Date: 15-Oct-2021
Our Ref: 2019/93309

**Application for Approval of Details Reserved by Condition
Town and Country Planning Act 1990
Planning (Listed Buildings and Conservation Areas) Act 1990**

**Discharge of conditions 4 (Ventilation) and 7 (Parking Management) of previous
application 2018/94181 for alterations to convert hotel (C1) to 10 student studios
(within a Conservation Area)
31-37, Beast Market & 1, Southgate, Huddersfield, HD1 1QF
Application Number: 2019/93309**

FIRST FLOOR PLAN - as proposed

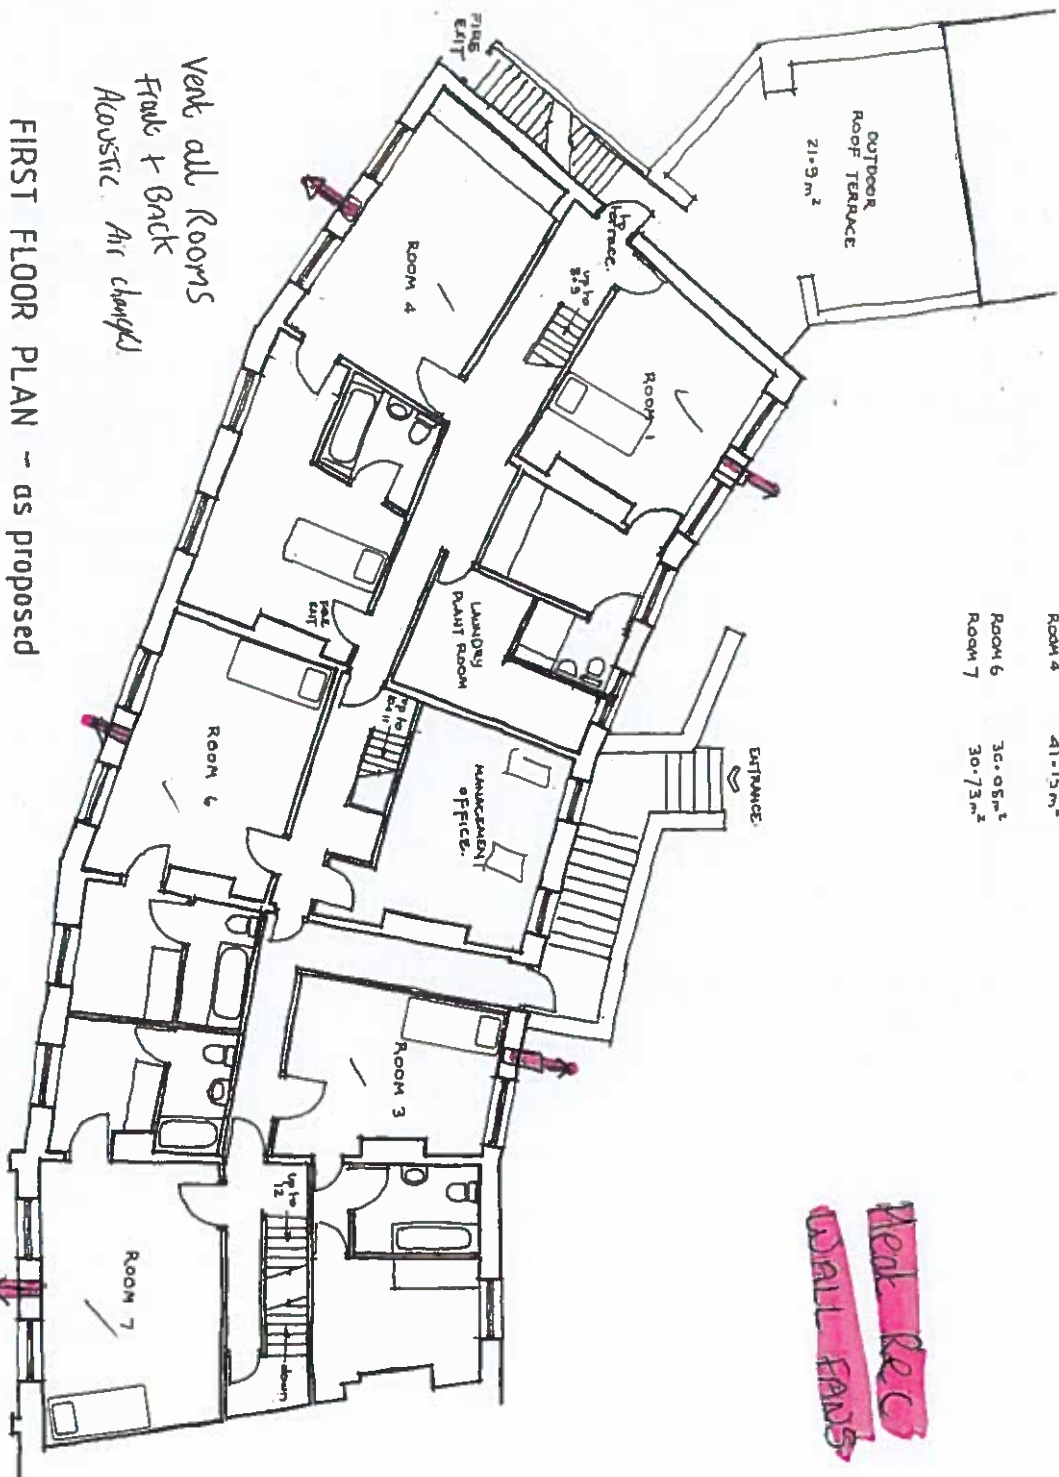
These details are considered insufficient to secure an appropriate ventilation scheme for
habitable rooms in the development to address air quality and noise mitigation issues.
Therefore, the condition cannot be discharged.
